**ADDENDUM #3**

**CITY OF PORTLAND, MAINE  
Riverton Expansion and Renovation Project  
BID #7706**

**ADDENDUM #3  
CITY OF PORTLAND  
RIVERTON EXPANSION AND RENOVATION PROJECT  
Portland, Maine**

This Addendum forms a part of the Contract Documents and modifies the original Bidding Documents dated May 9, 2006. Acknowledge receipt of this Addendum in the space provided in the Bid Form that has been included in the Project Manual.

DRAWING NAME:  
**D1 / A102**

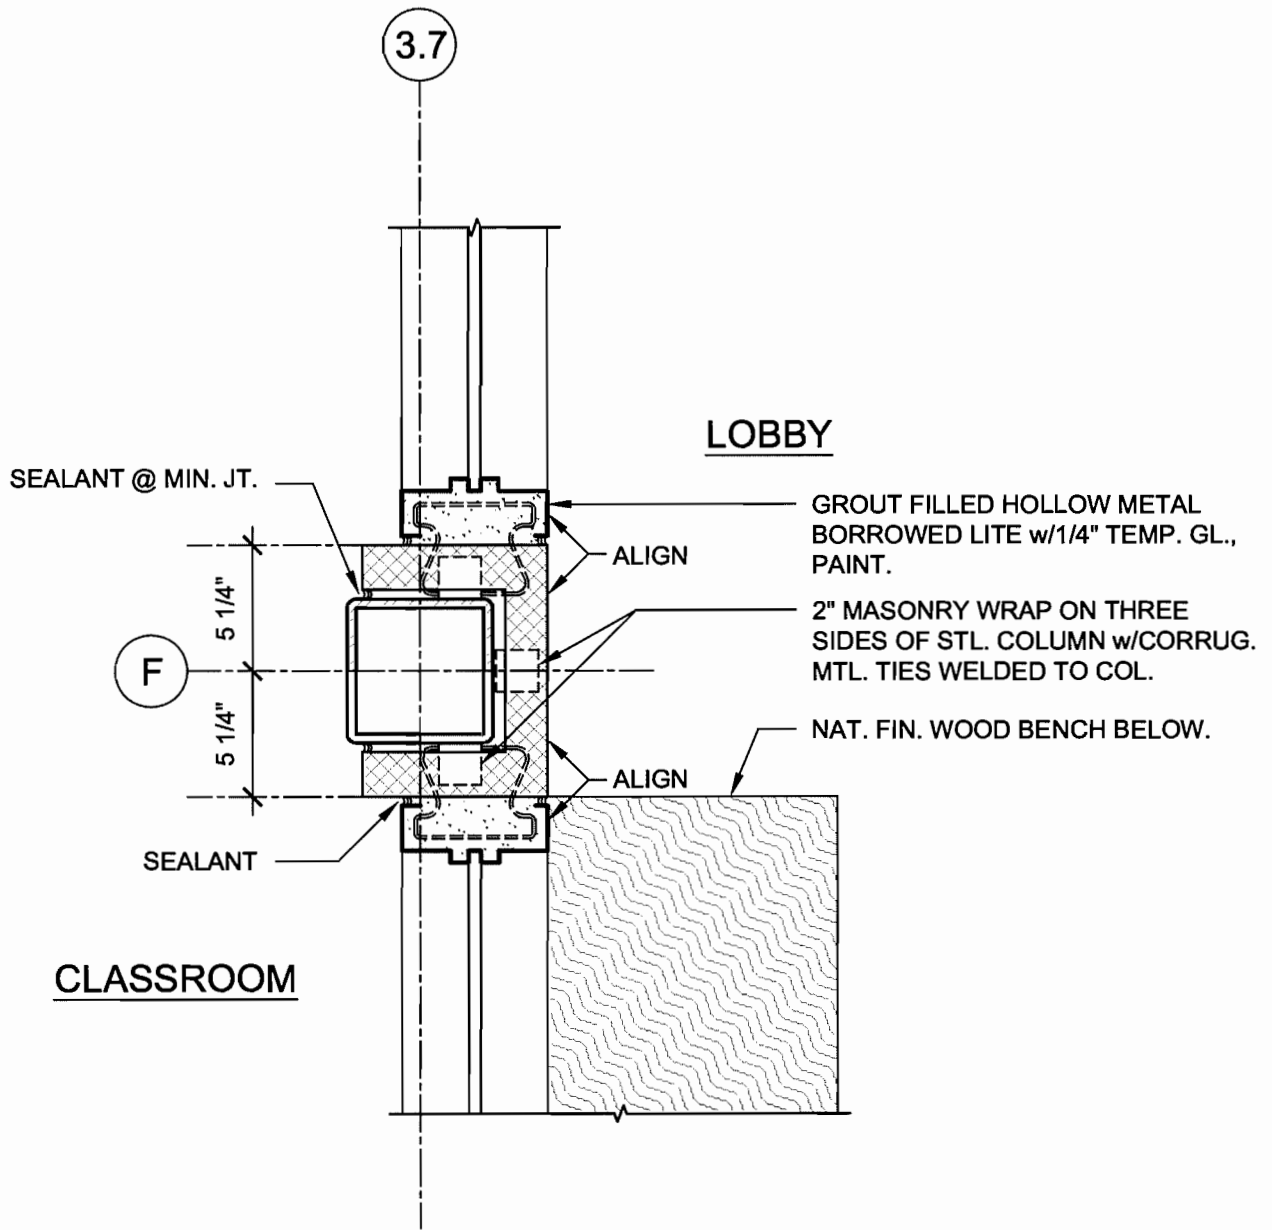
At Plan D1 – P&R Addition; **CHANGE** the Canopy Roof Plan (only) to be as shown on C/ASK-14 attached to this Addendum.
